I'm writing to you with respect to the development at Church Lane Linthwaite, and the associated drainage Conditions, as per the attached document.

I understand that Condition 17 & 18 remain undischarged, due to ongoing queries from the LLFA. I've copied in Paul Farndale, should he wish to contact me directly for discussion, but can you please upload and issue the linked information to your appropriate central database.

**“Condition 17 – Attenuation Basin**

### **Condition 18 – Flood Routing**

TITLE: EXTERNAL WORKS PLAN (3 OF 4)

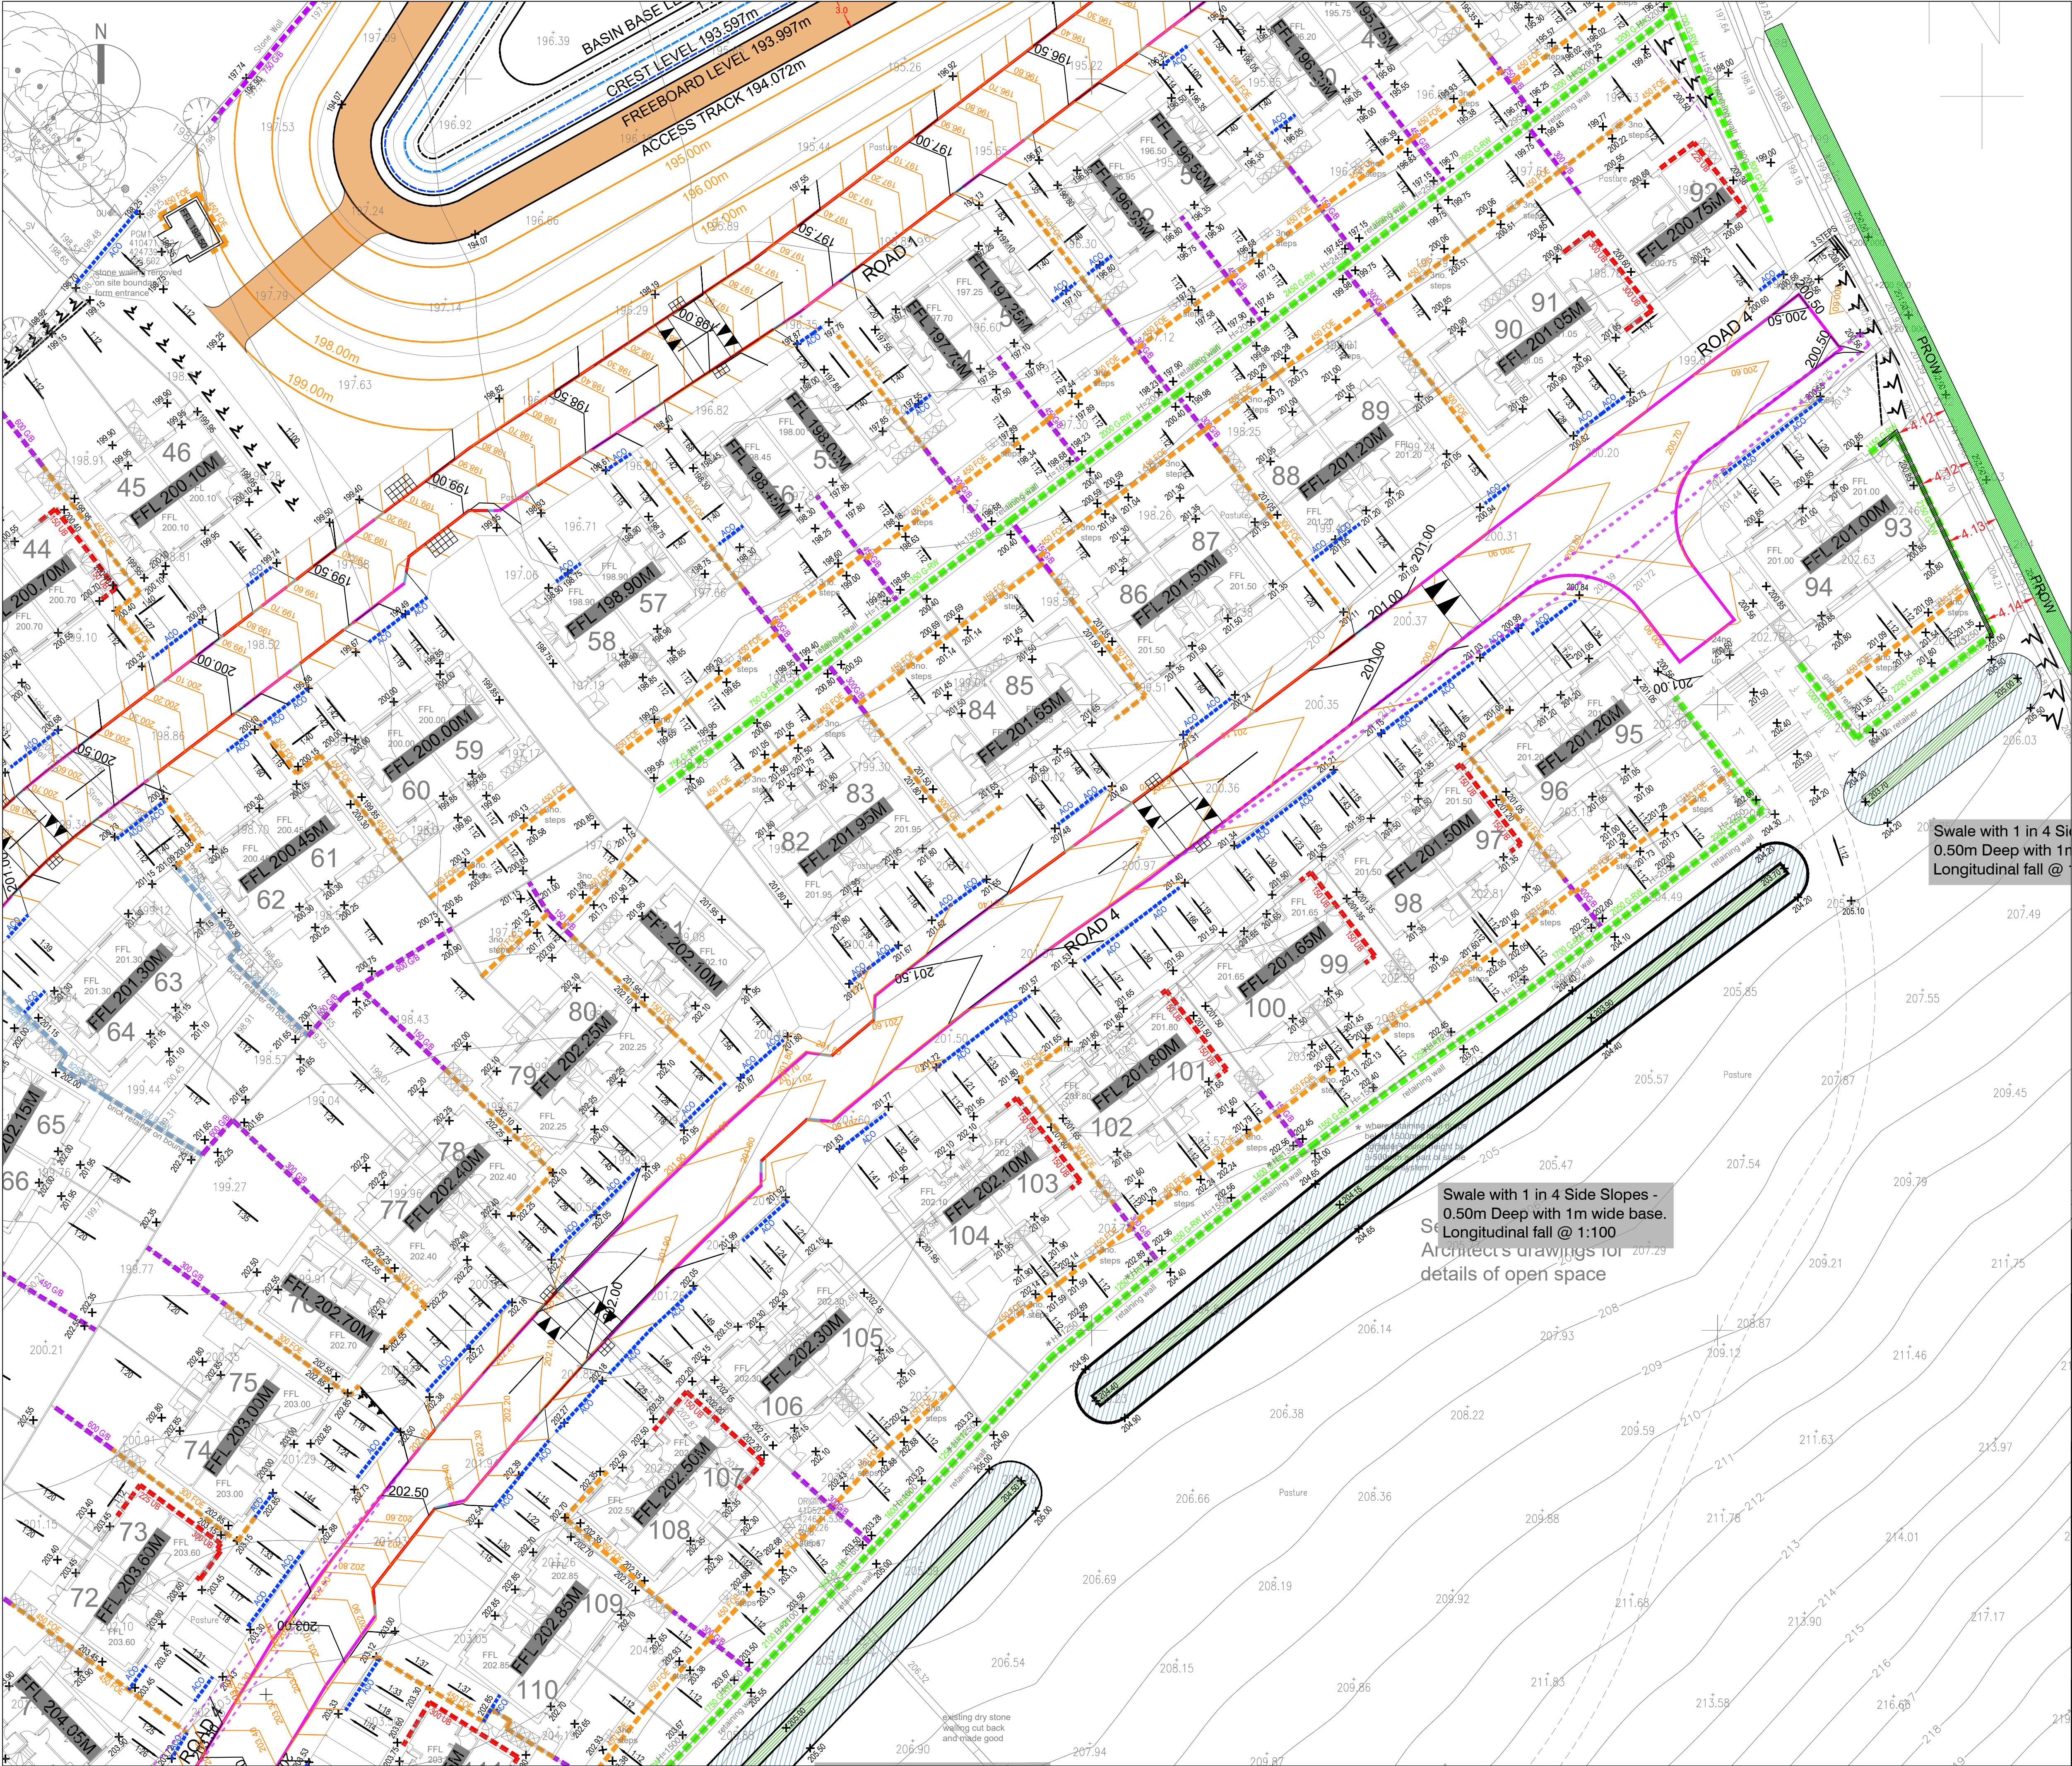
*Road contours have now been supplied but continue to show overland flow routes to a basin area in road 3. This is only acceptable if road three is isolated (use 10 properties as a marker). In initial discussions it was made clear on indicative plans that roads 2 and 1 should be used to contain overland flow into Kinder Avenue (where this has been experienced in the past), avoiding basins and new property curtilage. This has not happened. A swale has been shown prior to the southern plots backing onto sloping ground to protect these properties from surface run off. However, no levels have been shown for the swale, just a contour profile for the land suggesting low spots at the backs of properties and that they will be at risk. Flows should escape using the road network and/public open spaces, avoiding property curtilage. A detailed examination of levels is therefore required here to prove it is achievable.*

**We have received the levels of Road 3 to avoid a basin area, this was submitted and approved through the S38 process, with Road 3 sufficiently lifted to avoid creating this effect. Additional levels to the external works plan are shown for the Swales to demonstrate transfer of flows away from properties. The new level scheme also eliminates are Flooding for the 1 in 100 year storm event.**
